From: Simon Davis
Sent: 06 December 2018 09:35
To: 'Nick Hopper'
Cc: Trish Paul
Subject: RE: Amended Highfield RD.

From: [REDACTED]
Sent: 05 December 2018 15:32
To: Simon Davis; Trish Paul
Subject: Amended Highfield RD.

Please find attached amended proposals for Highfield Rd application following your advice. Please note reduced size, addition of parking bay to front elevation, reduced mass and bulk of exterior profile, reduced overlooking to South and West elevations.

Parking Sweep Diagram 1:200

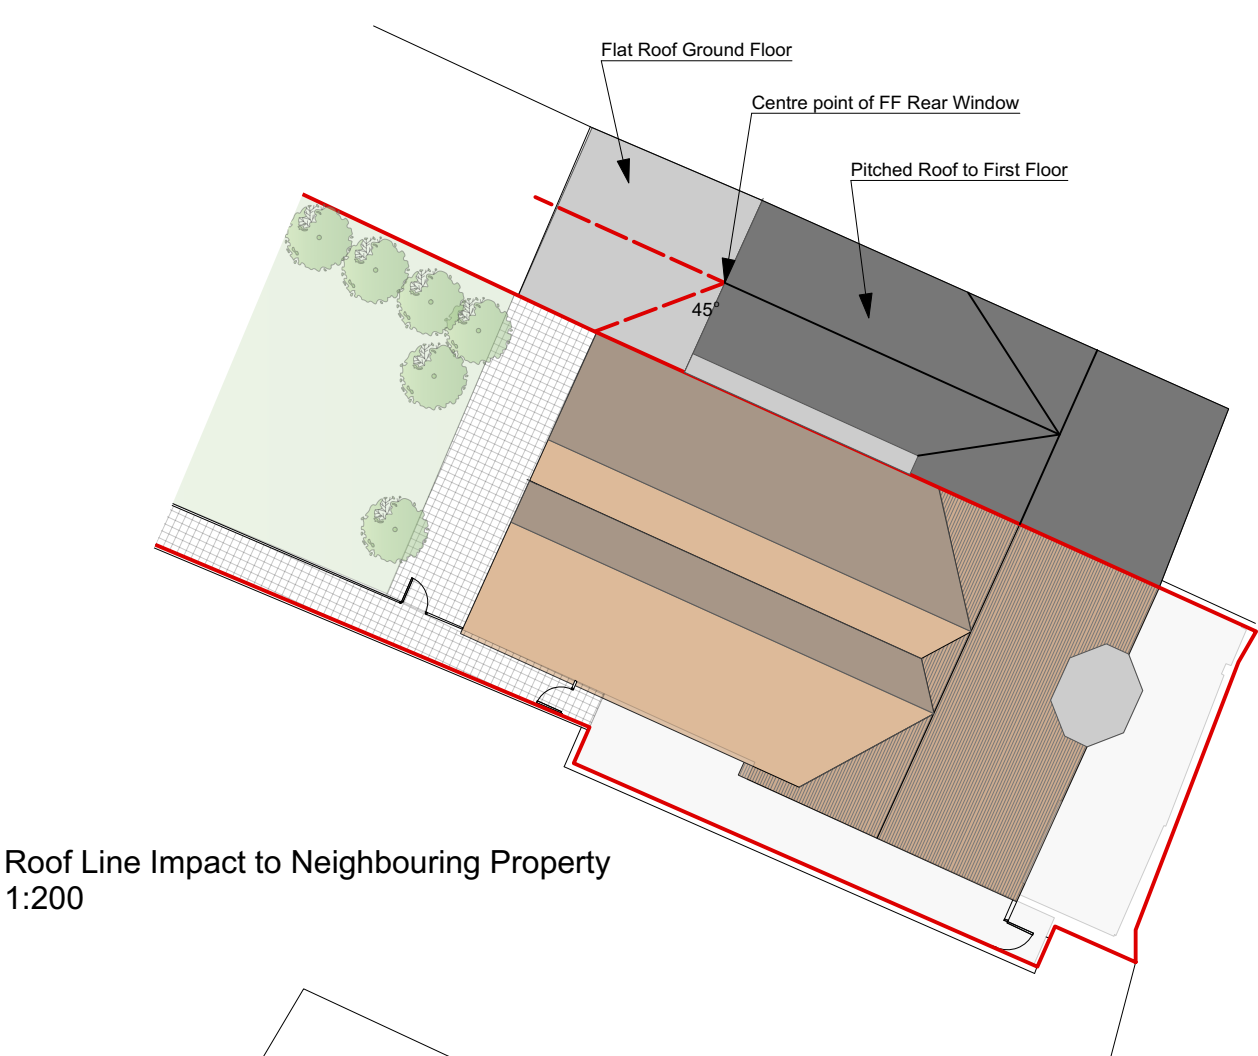
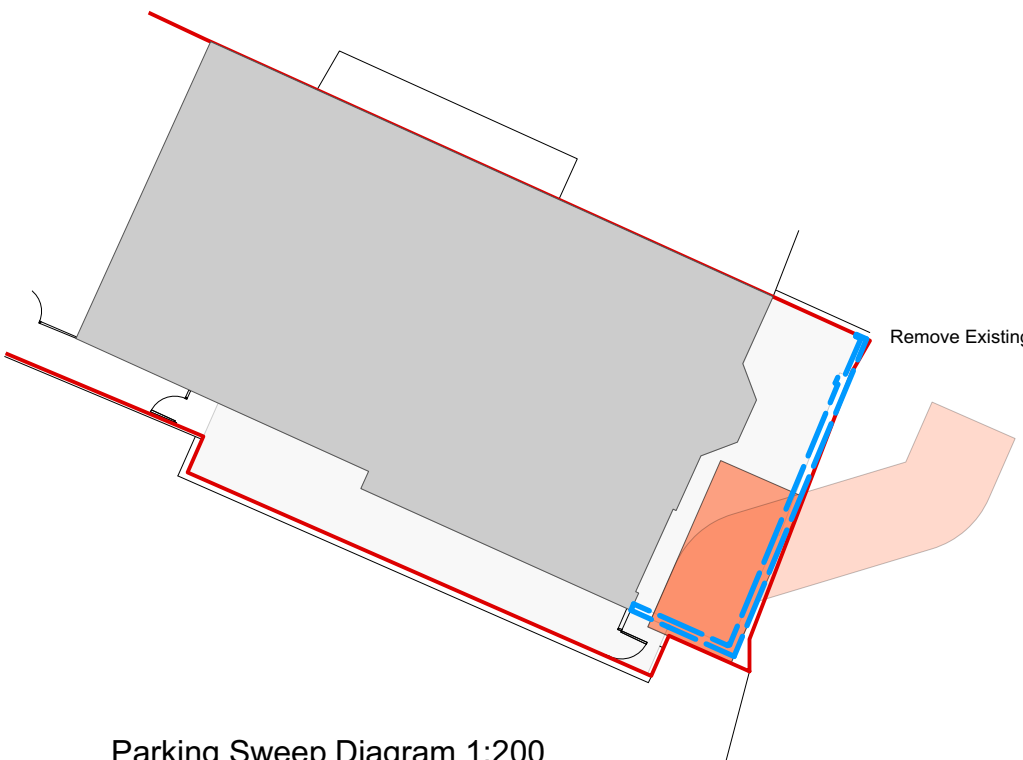
This certainly looks better but I'm going to need to discuss with my Team Leader when I'm back in the office on Monday (working at home today, tomorrow) before I can advise if it will allow a positive recommendation. However, in the meantime, can you advise how the parking space will work given the existing front/front side boundary walling, the telegraph pole and likely parking on street to the front of the building. A tracking diagram might assist.
